Nestor Tsambos
Team Leader – Planning
Solar and Battery Assessments
Department of Planning, Housing and Infrastructure

Our ref: DOC25/799823
Your ref: SSD-29508870-Mod-1

Birriwa Solar and Battery Project Modification 1 (SSD – 29508870-Mod-1) – Modification Report

Birriwa Solar and Battery Project Modification 1 – Modification Report

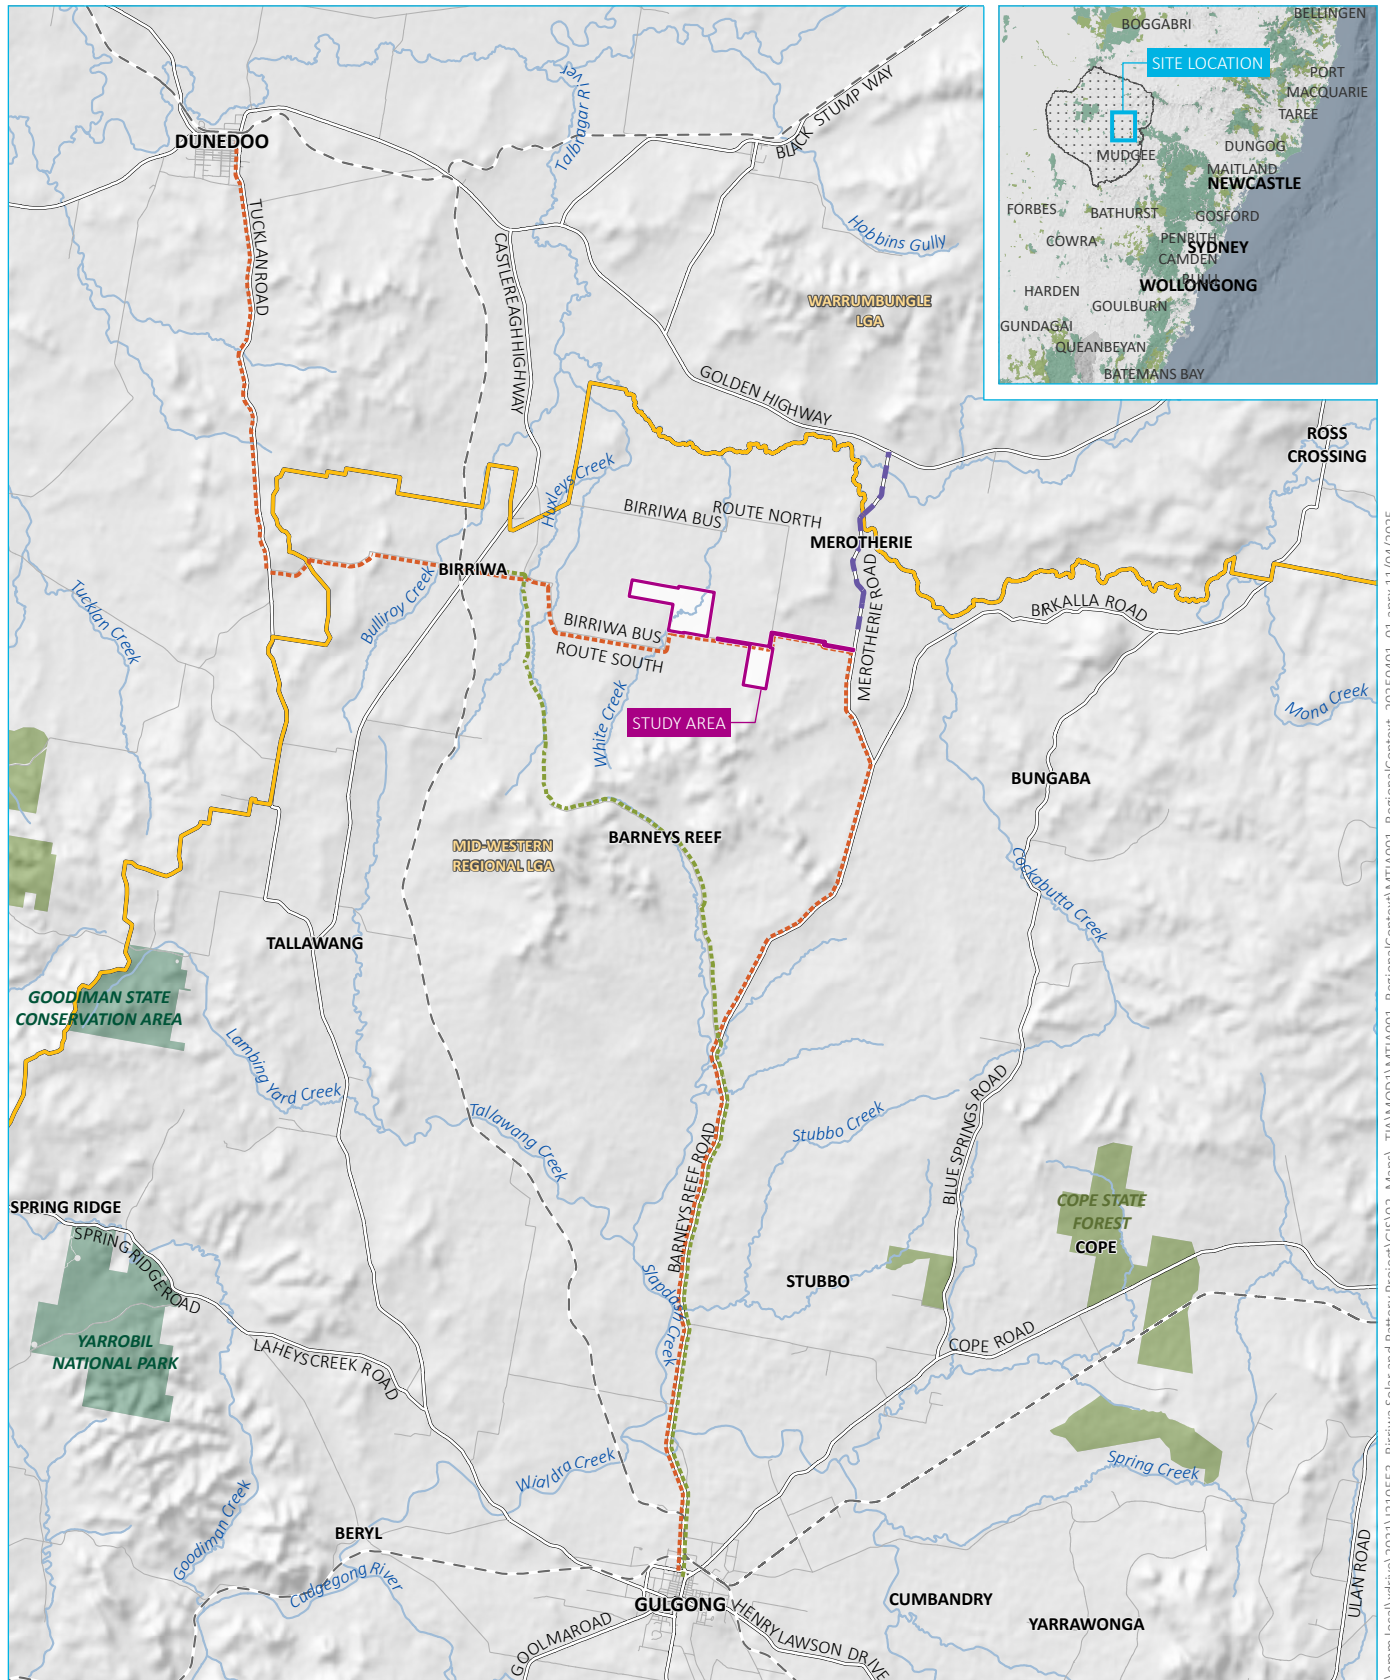
The modification report and Traffic Impact Assessment state that the proponent will be upgrading the Merotherie Road/Birriwa Bus Route South intersection, in addition to the proposed upgrade of BBRS. Both reports indicate this work forms part of the proposed modification and is subject to final design to the satisfaction of Mid-Western Council. The Modification Report and Traffic Impact Assessment (Figures 1 and 2) indicate potential impacts associated with the road intersection upgrade which are not addressed in either BDAR provided.

The sight distances on Merotherie Road from Birriwa Bus Route South have been estimated based on the line of sight, as shown in Figure 6.4. Based on the sight distance analysis, a number of mature trees may require removal on the western side of Merotherie Road as circled in Figure 6.4, as per the final design to the satisfaction of Mid-Western Regional Council.

- 2.1 Clarify the extent of direct impacts associated with the modification and ensure these are assessed in accordance with the BAM.
